RV105-A6
Serial number: 41232
Customer: Brown

This letter is to confirm that Truss CCB37709 from the permit package is to be replaced with truss # CCB3711.

Job 91192	Truss CCB37711	Truss Type CAPE COD	Qty 1	Ply 1	Commodore 315 NC R41P9F (WITH BEARING AT OH 1 SIDE) Ref. #3157426
---------------------	--------------------------	-------------------------------	-----------------	-----------------	---

Job <b>91192</b>	Truss <b>CCB37711</b>	Truss Type <b>CAPE COD</b>	Qty <b>1</b>	Ply <b>1</b>	<b>Commodore 315 NC</b> R41P9F (WITH BEARING AT OH 1 SIDE) Ref. #3157426
---------------------	--------------------------	-------------------------------	-----------------	-----------------	--

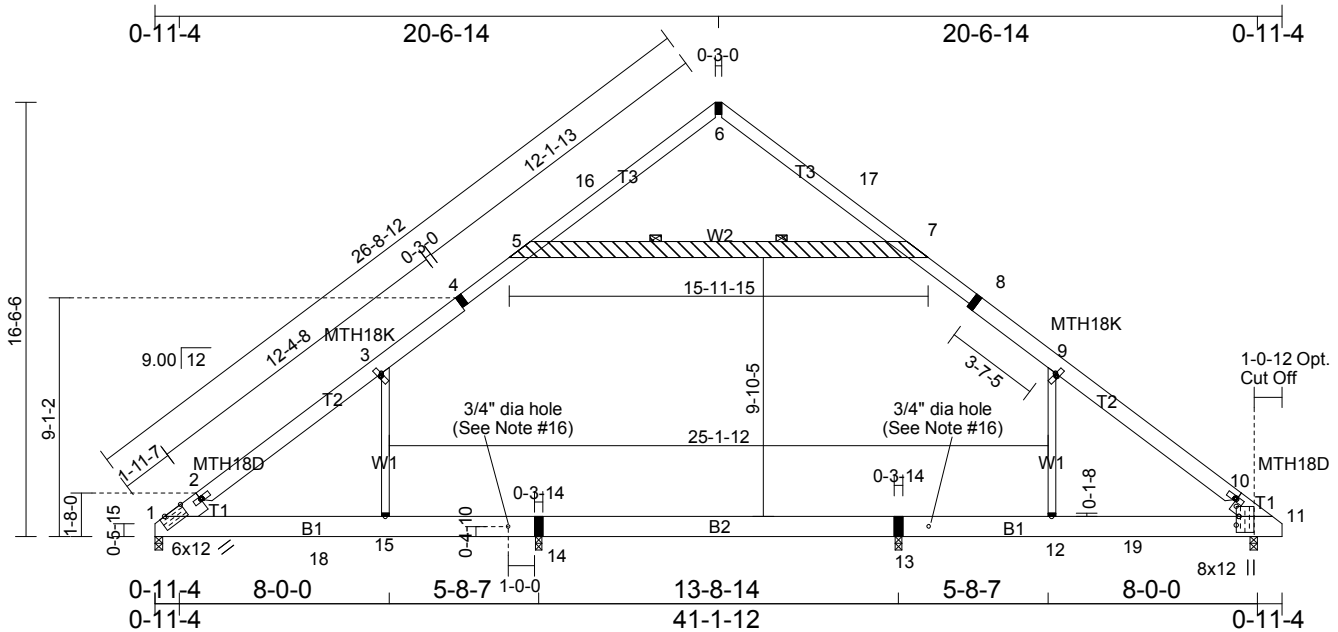
- 20) Based on: CCB37709
- 21) Revision: Removed bottom chord scabs, added hole note.
